# TIERRA WEST, LLC

April 29, 2024

**RE: 2022031 LOVES SUNPORT BLVD  
ALBUQUERQUE, NEW MEXICO**

CONDITIONS OF APPROVAL –SI-2023-00691

TRAVEL CENTER EXHIBIT
AIR SPACE PROTECTION HORIZONTAL SURFACE
(3-3(B)(1))PROPOSED STRUCTURE HEIGHTS/ELEVATIONS
FALL BELOW THE AIR SPACE PROTECTION HORIZONTAL
SURFACE ELEVATION OF 5504.90

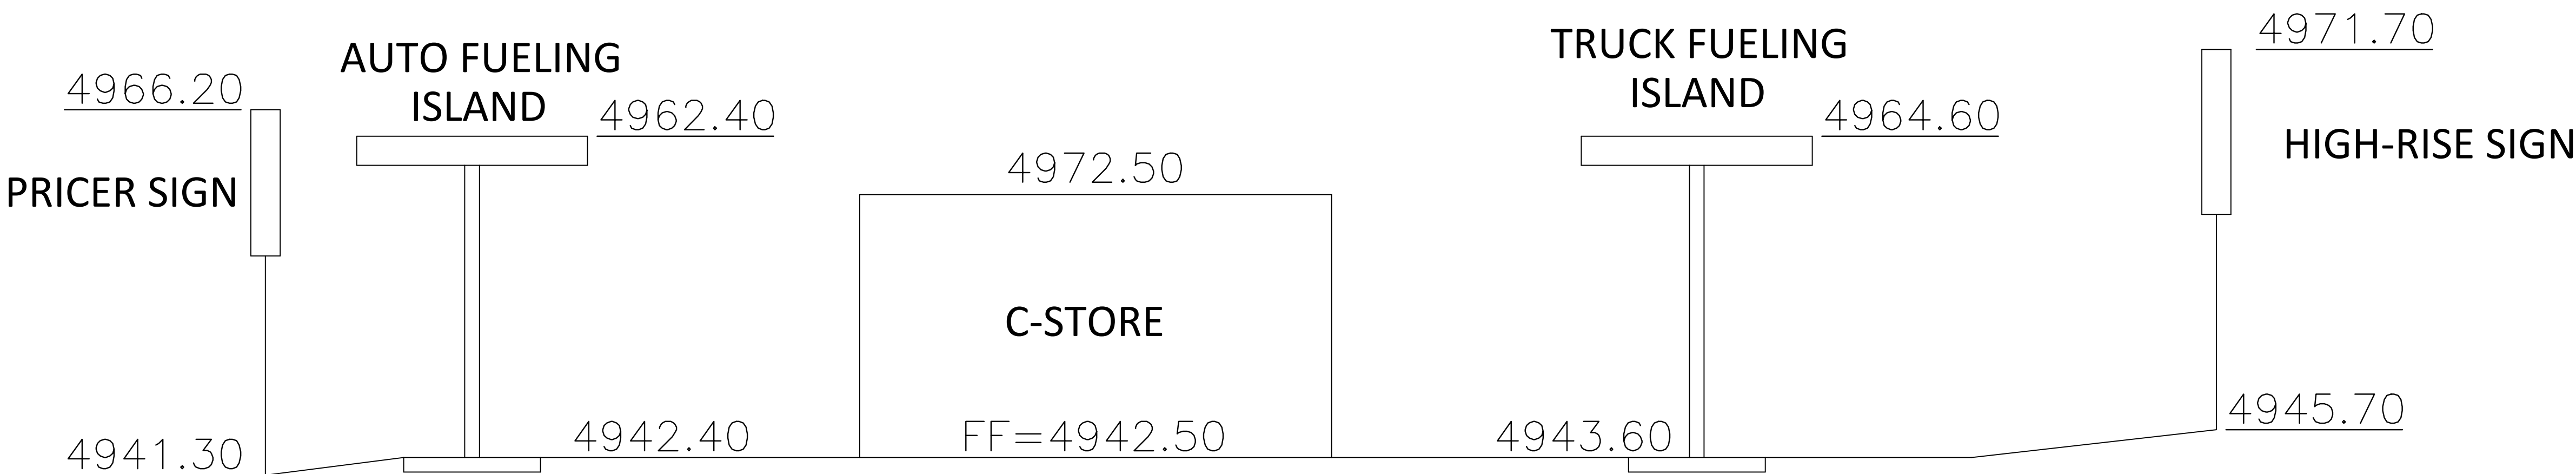
- a. The Airspace Protection Sub-Area analysis shall be its own detail sheet.

**The Airspace Protection Sub-Area analysis detail was moved to its own detail sheet DET-6.**

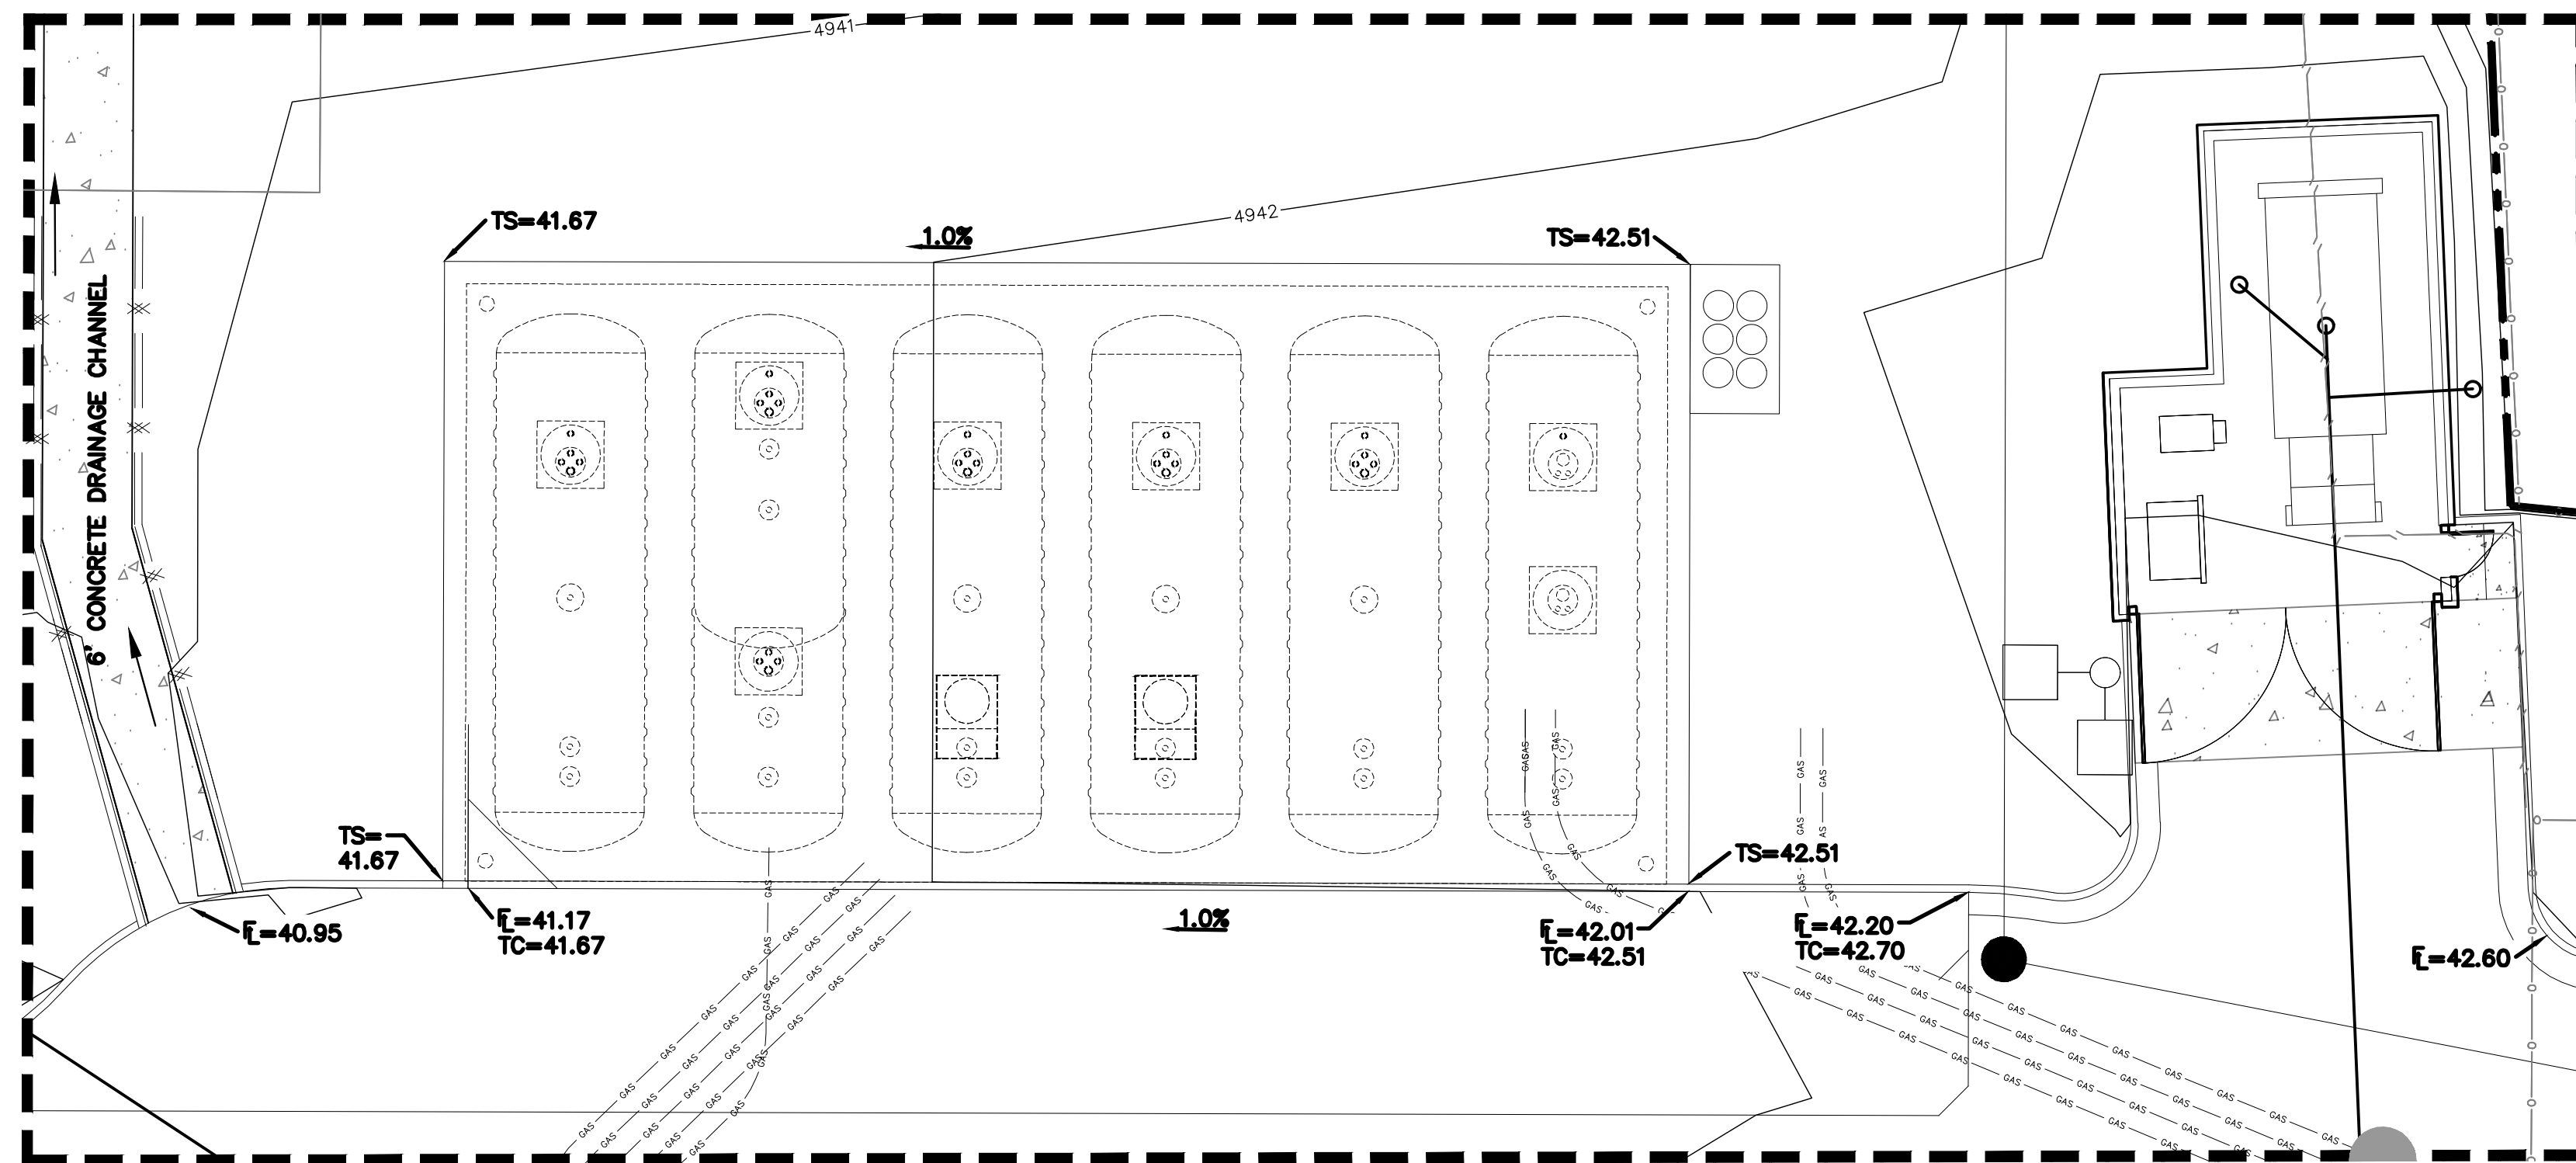
10. Grading and Drainage Plan: The Drainage narrative shall be updated to state that the northern portion of the site is proposed to be redeveloped as a Travel Center, not the southern.

**The drainage narrative on GR-1 was updated to note that the northern portion of the site is proposed for redevelopment.**

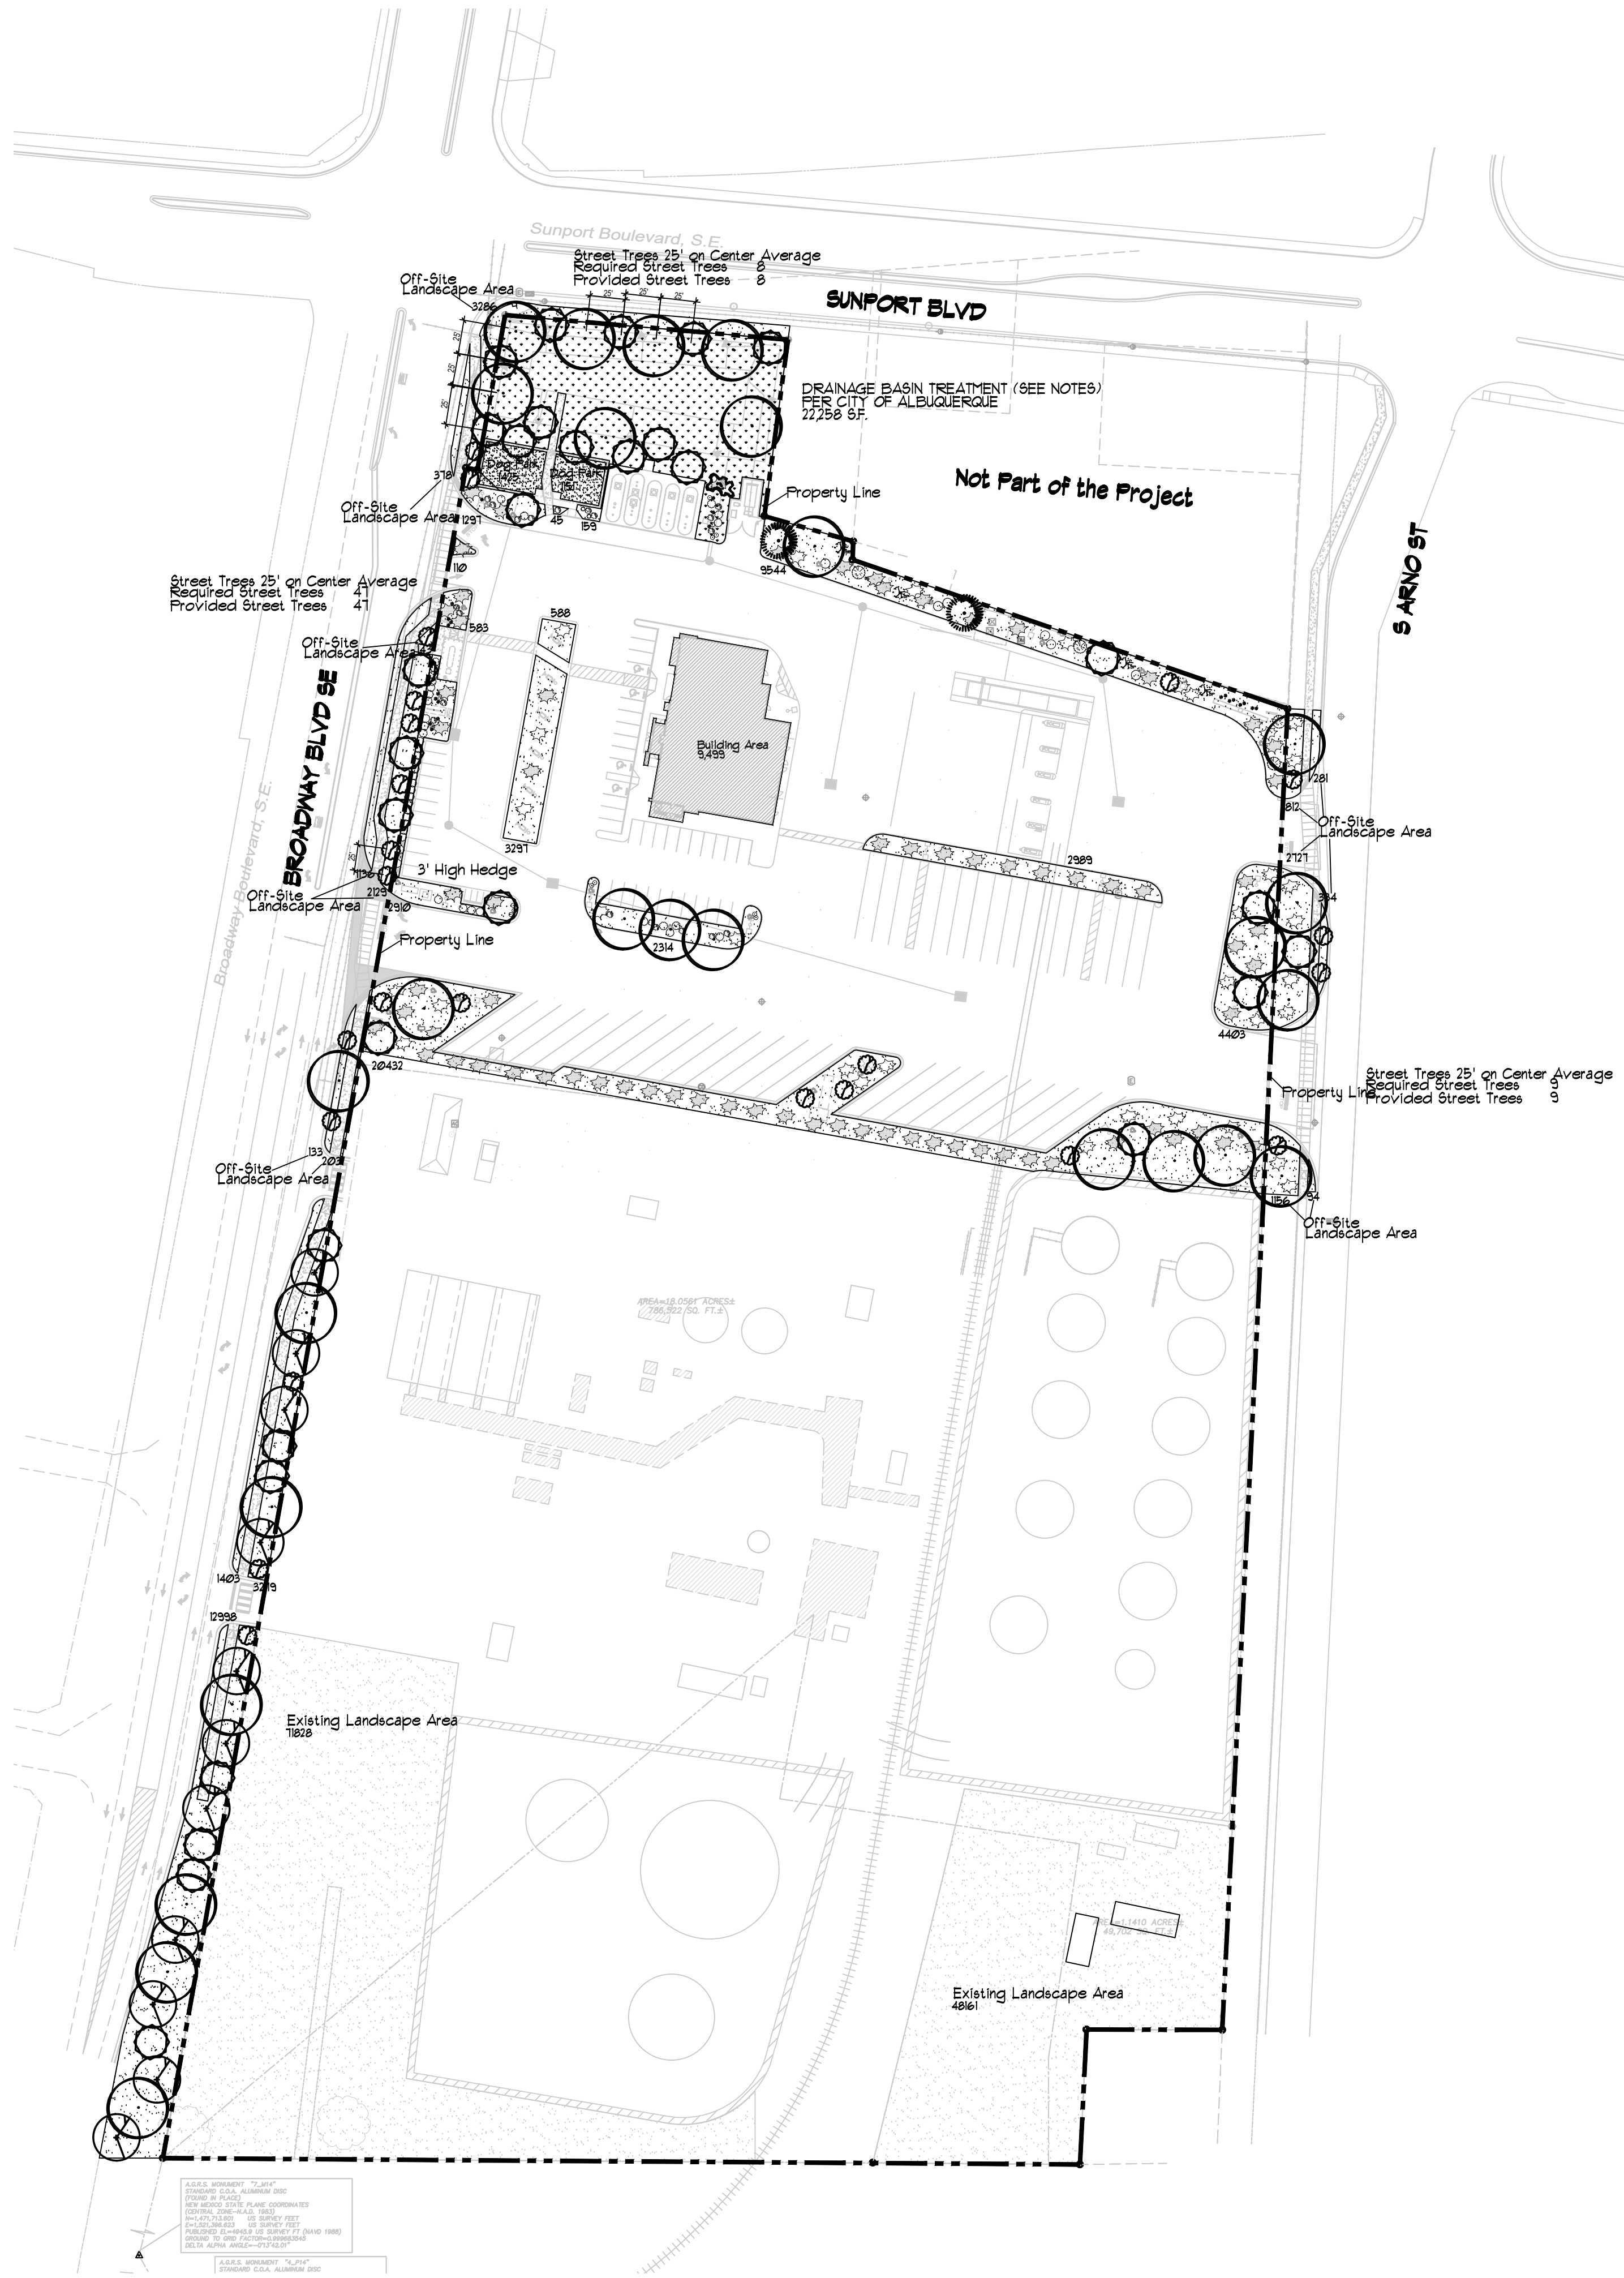
- a. The Buffalo Juniper species of shrub shall be female only.

- b. The note stating that the southern portion of the site is "not a part of project" shall be removed. The 15-acre portion of the site is included with this request.

- c. The title of the Landscape plan shall be changed to \_\_\_\_\_

- d. The lot area shall be updated to reflect the total lot area on the site plan sheet and landscape sheet. Landscape calculations shall be updated based on this total.

**A note was added on sheet LS-101 that this species of shrub will be "female only".**

**This note has been removed and the 15-acre portion of the site has been included with this request.**

**The Landscape Plan title is now Loves Travel Center.**

**The total lot area is now reflected in the site plan and landscape plan sheets. The landscape calculations were updated based on the total lot area.**
